EPC STORMWATER REVIEW COMMENTS ARE SHOWN IN ORANGE BOXES WITH BLACK TEXT

A-1 Chipseal Operations and Maintenance Manual Sand Filter

County Job No. COM-22-014

SAND FILTER DESIGN – PLAN VIEW
N.T.S.

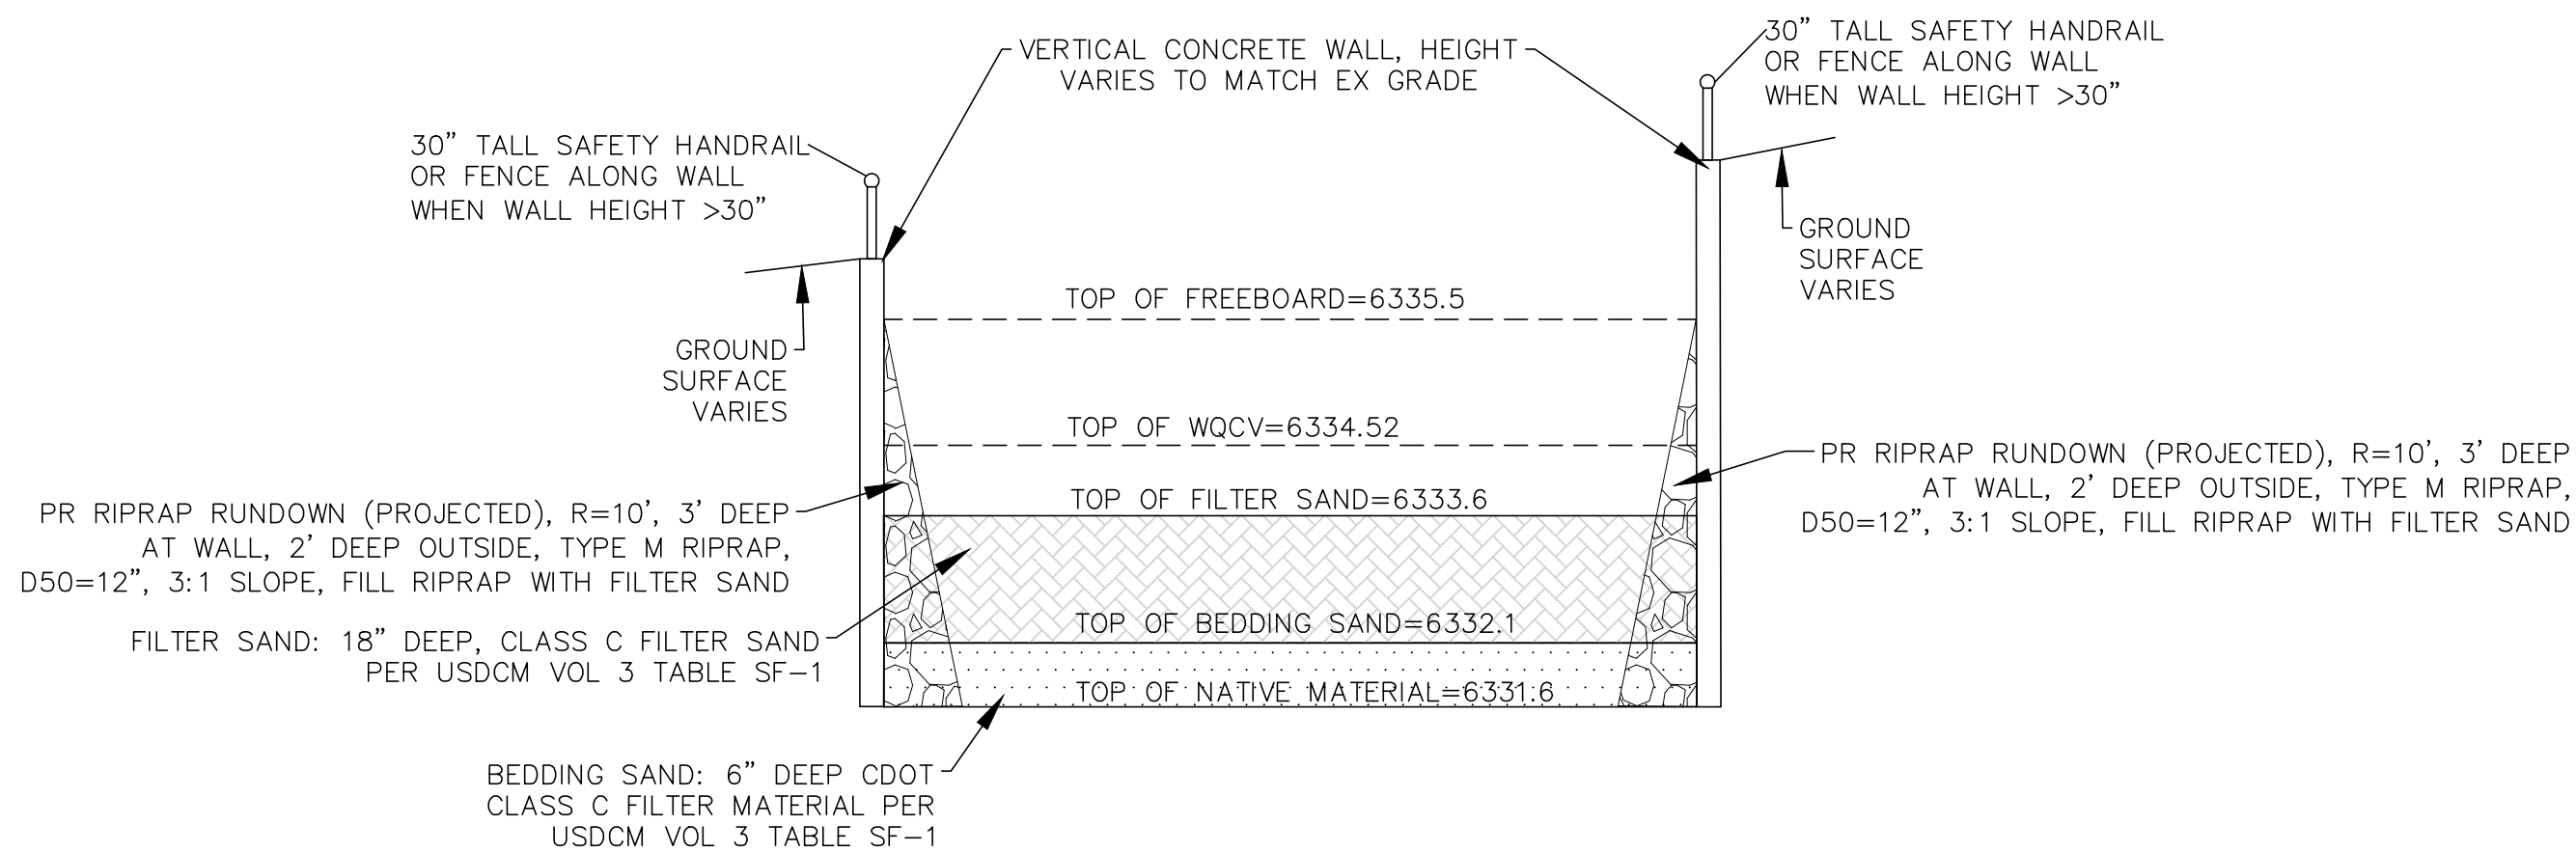
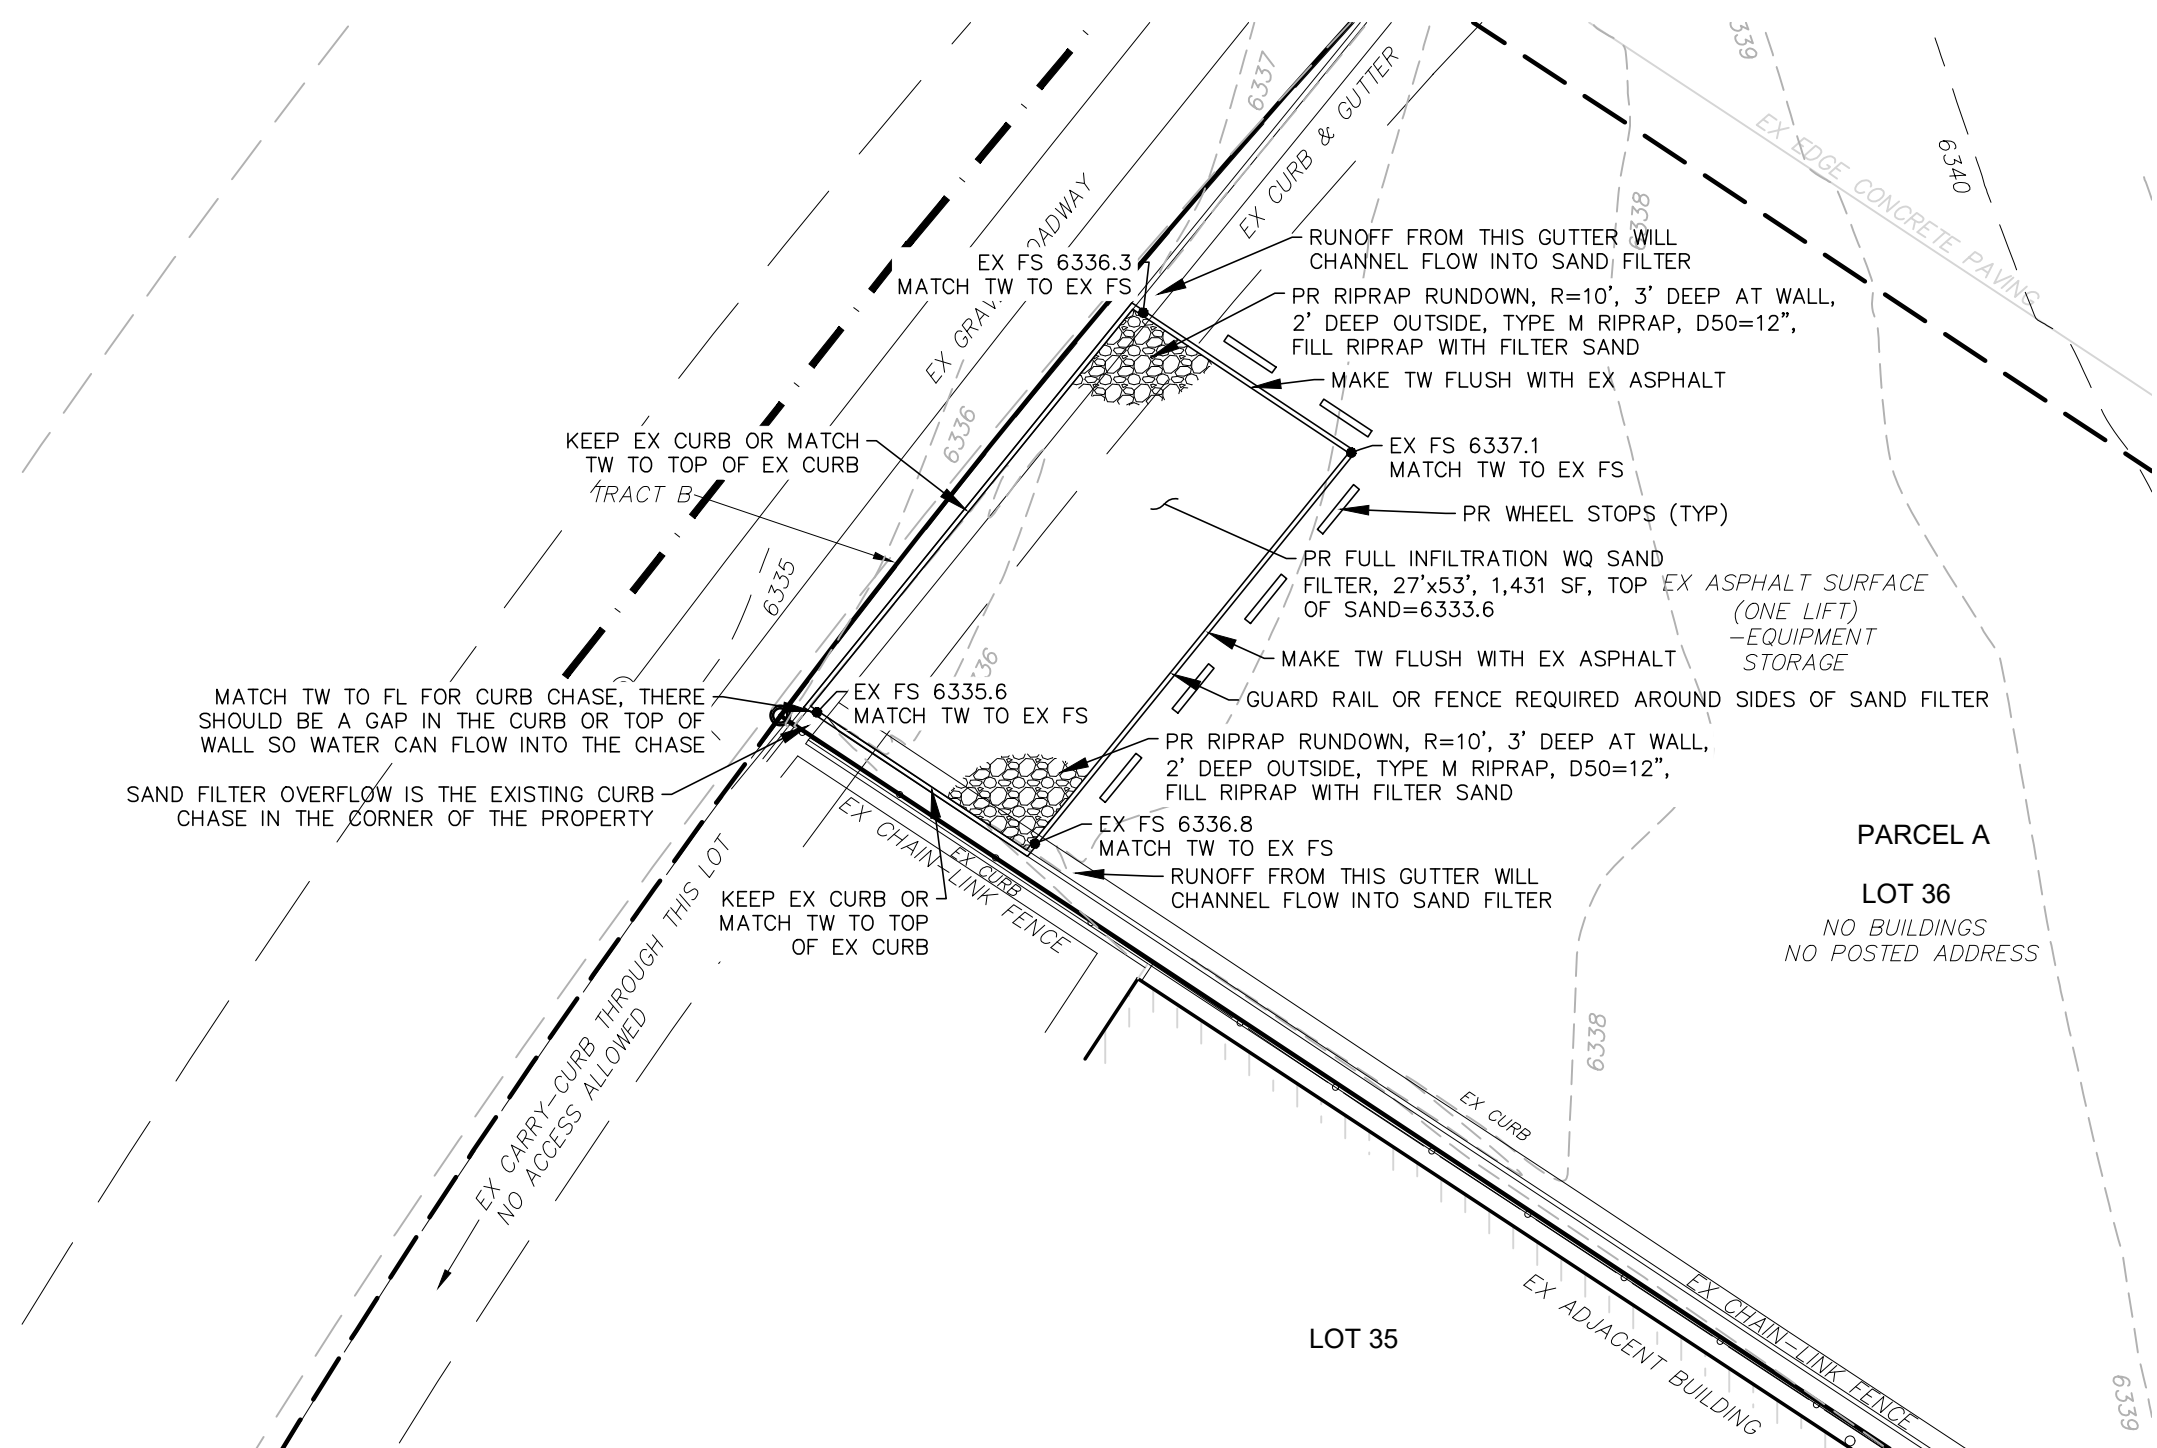
Sand Filter Basins (SFBs) are a common type of Stormwater Management facility utilized within the Front Range of Colorado. A SFB consists of a flat surfaced area of sand ~~(sometimes covered with grass or sod)~~, a filtration chamber, and a flat sand filter bed ~~with an underdrain system~~. A surcharge zone exists within the filtration chambers for temporary storage of the Water Quality Capture Volume (WQCV). During a storm, runoff enters the filtration chamber where it ponds above the sand bed and gradually infiltrates into the underlying sand filter, filling the void spaces of the sand. The ~~underdrain gradually dewateres the sand bed~~ discharges the runoff to a nearby channel, ~~swale, or storm sewer~~. SFBs provide for filtering and absorption of pollutants in the stormwater. The popularity of SFBs has grown because they allow the WQCV to be provided on a site that has little open area available for stormwater management. However, there are limitations on their use due to potential clogging from large amounts of sediment.

Inflow points or outfalls into SFBs are the point of stormwater discharge into the facility. An inflow point is commonly a curb cut with a concrete ~~or riprap rundown or a storm sewer pipe outfall with a flared end section.~~
